HASH-00-SD-BC-RP-0001

BCA ASSESSMENT REPORT

Hurlstone Agricultural High School
(Hawkesbury)

October 2017

DRAWING
Level 01 GA

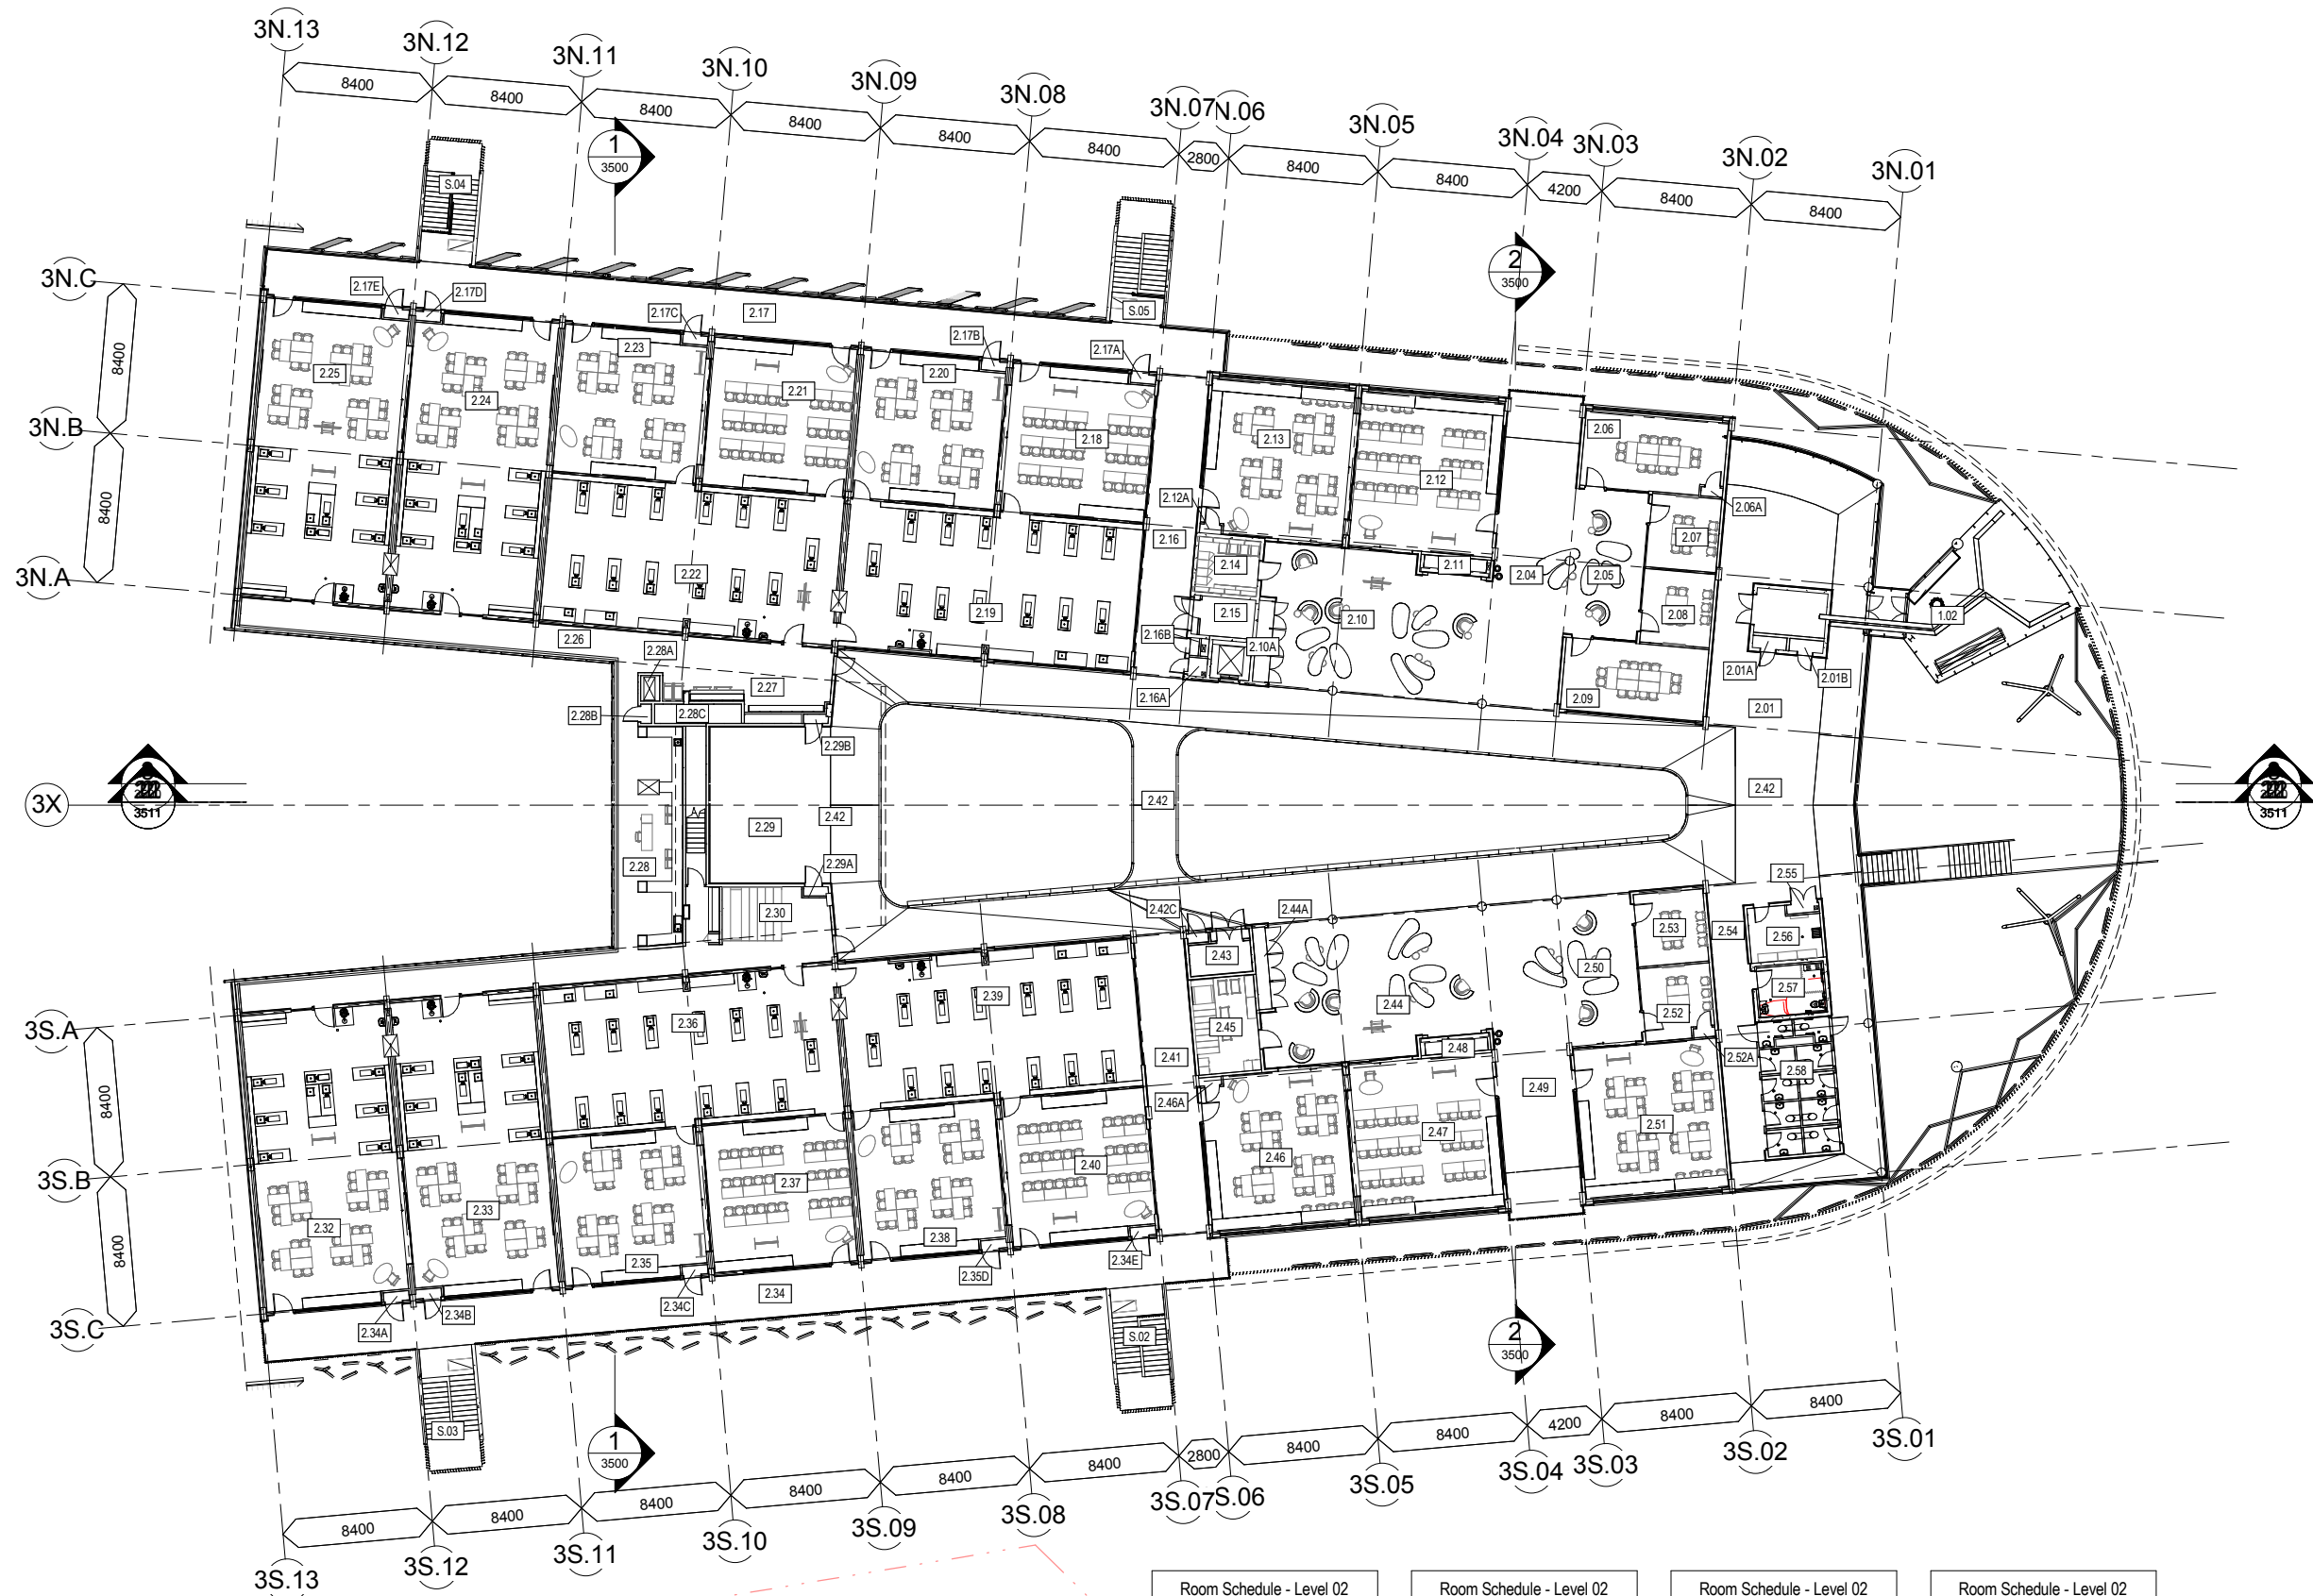
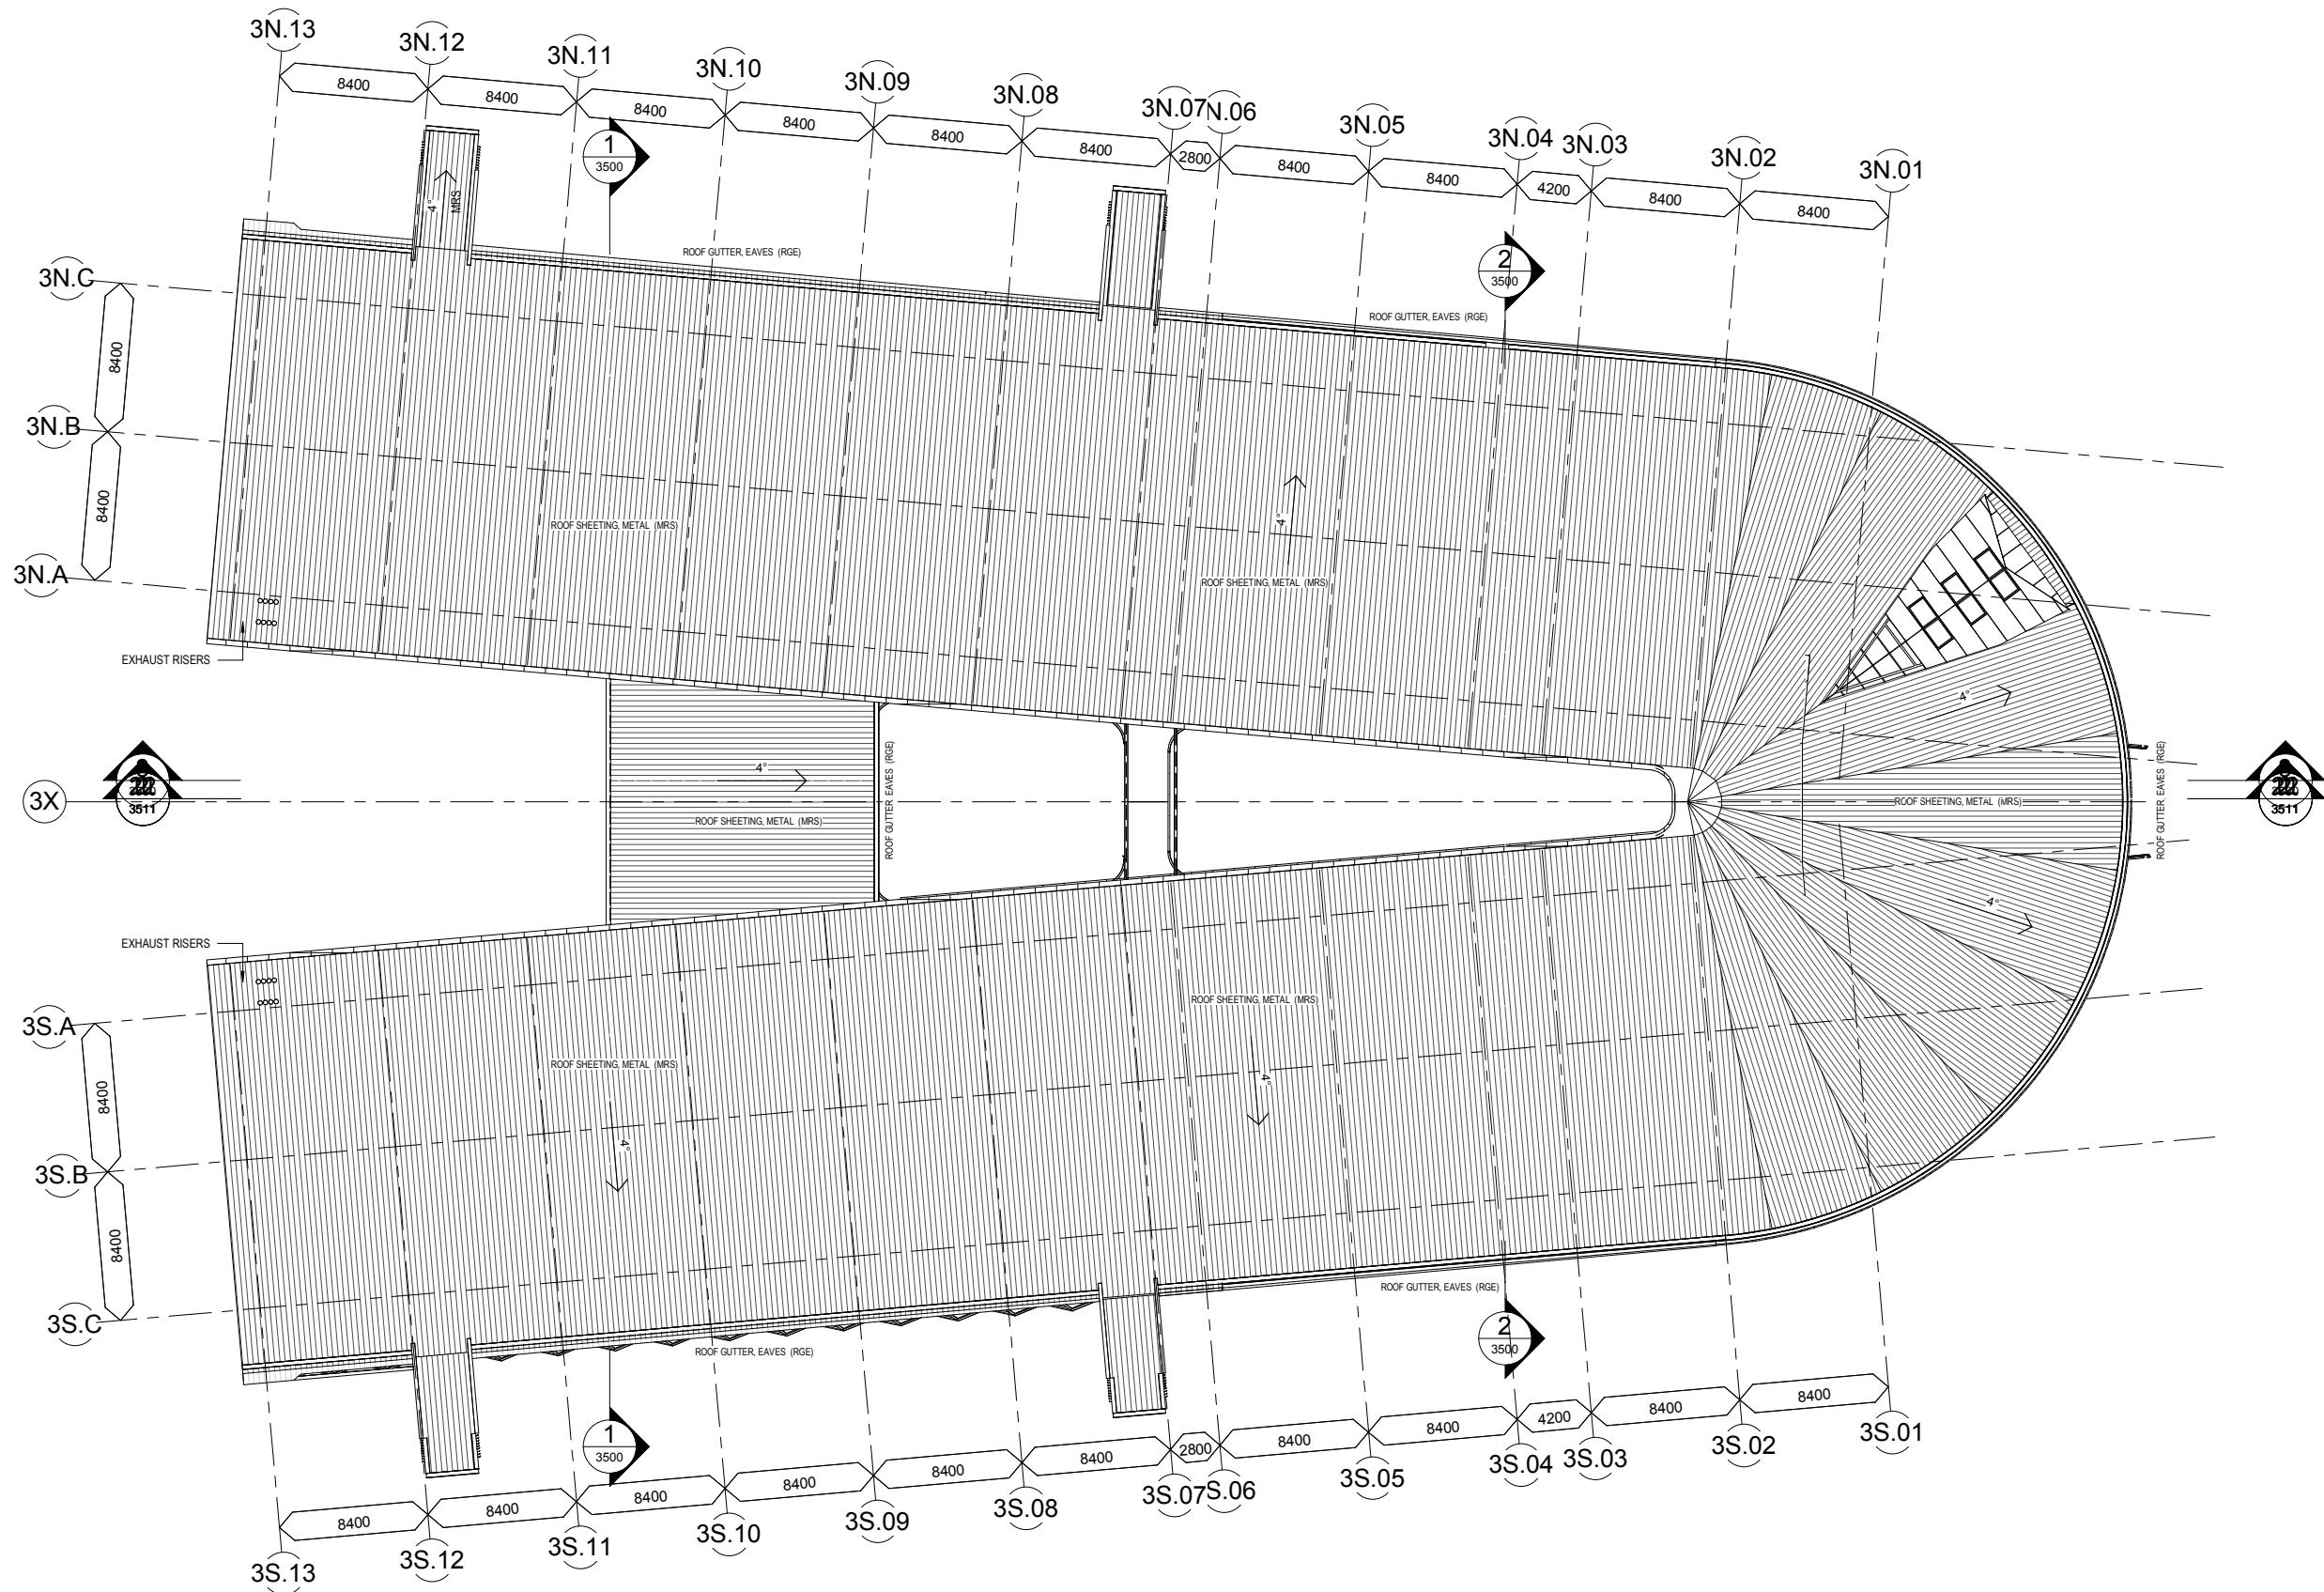
2.	D1.2	The plant room in Building 4 is proposed to be provided with a single exit in lieu of the required 2 exits.	DP4
3.	D1.4	Distances exceed the maximum 40m to an exit (up to 45m) on Level 1 and 2 of Building 3	DP4 and EP2.2

4.	D1.5	Distances measured between exits in Building 3 (level 1 and 2) exceed the maximum 60m, up to 88m.	DP4
5.	D1.8	Stairs in Building 2 and 3 do not comply with the fire separating requirements of this clause (Note: this clause does not apply to Stair 2 in Building 2)	DP5
